**Planning Department
Transportation Development Services**

**Re: T-Mobile Store
5350 Academy Rd., NE
Traffic Circulation Layout
Engineer's/Architect's Stamp dated 5-13-15 (E18-D030A)**

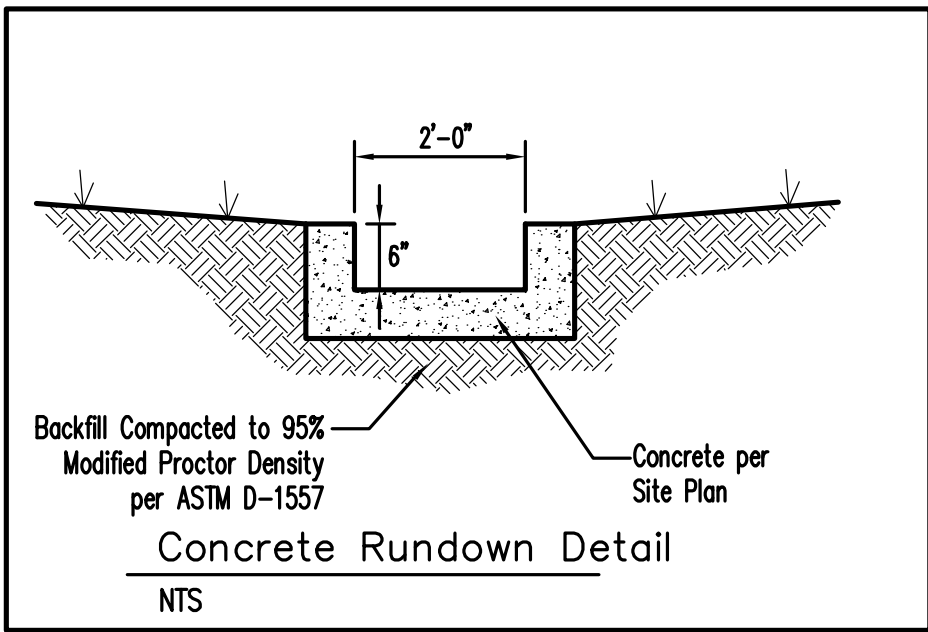
1. Please identify all proposed, doors, structures, sidewalks, curbs, drive pads, walls and anything that influences the parking and circulation on the site.

2. Identify all existing access easements and rights of way with dimensions from Academy Blvd. Please detail the side walk dimensions on Academy Blvd.
3. Please list the width and length for all parking spaces. Per DPM, parking spaces at a minimum must be 8.5 ft. width by 18 ft. in length for regular cars and 8 ft. wide by 15 ft. in length for compact cars.

4. Label the compact parking spaces by placing the words "**COMPACT**" on the pavement of each space.
5. The ADA van accessible sign must have the required language per 66-7-352.4C NMSA 1978 "**Violators Are Subject to a Fine and/or Towing.**"

6. Show all drive aisle widths and radii. Please dimension the parking lot entrances on the east and west side of the project site.
7. Per the DPM, a 6 ft. wide ADA accessible pedestrian pathway is required from the public sidewalk to the building entrances. Please clearly show this pathway from Academy Blvd. and provide details of ADA ramps per COA Standard Drawing No. 2441 for all side walk and pedestrian walk ways.

8. Per the DPM, a 6 ft. wide ADA accessible pedestrian pathway is required from the HC parking stall access aisles to the building entrances. Please clearly show and detail this pedestrian pathway.

9. Design delivery vehicle route needs to be shown.
10. Service vehicle and/or refuse vehicle maneuvering must be contained on-site; provide a copy of refuse approval.
11. Please provide a sight distance exhibit (see the *Development Process Manual, Chapter 23, Section 3, Part D.5 Intersection Sight Distance*) for the entrances off of Academy Blvd.

12. Please add the following note to the clear sight triangle: "Landscaping and signage will not interfere with clear sight requirements. Therefore, signs, walls, trees, and shrubbery between 3 and 8 feet tall (as measured from the gutter pan) will not be acceptable in this area."
13. Please include a copy of your shared access agreement with the adjacent property owner.
14. Please include two copies of the traffic circulation layout at the next submittal.
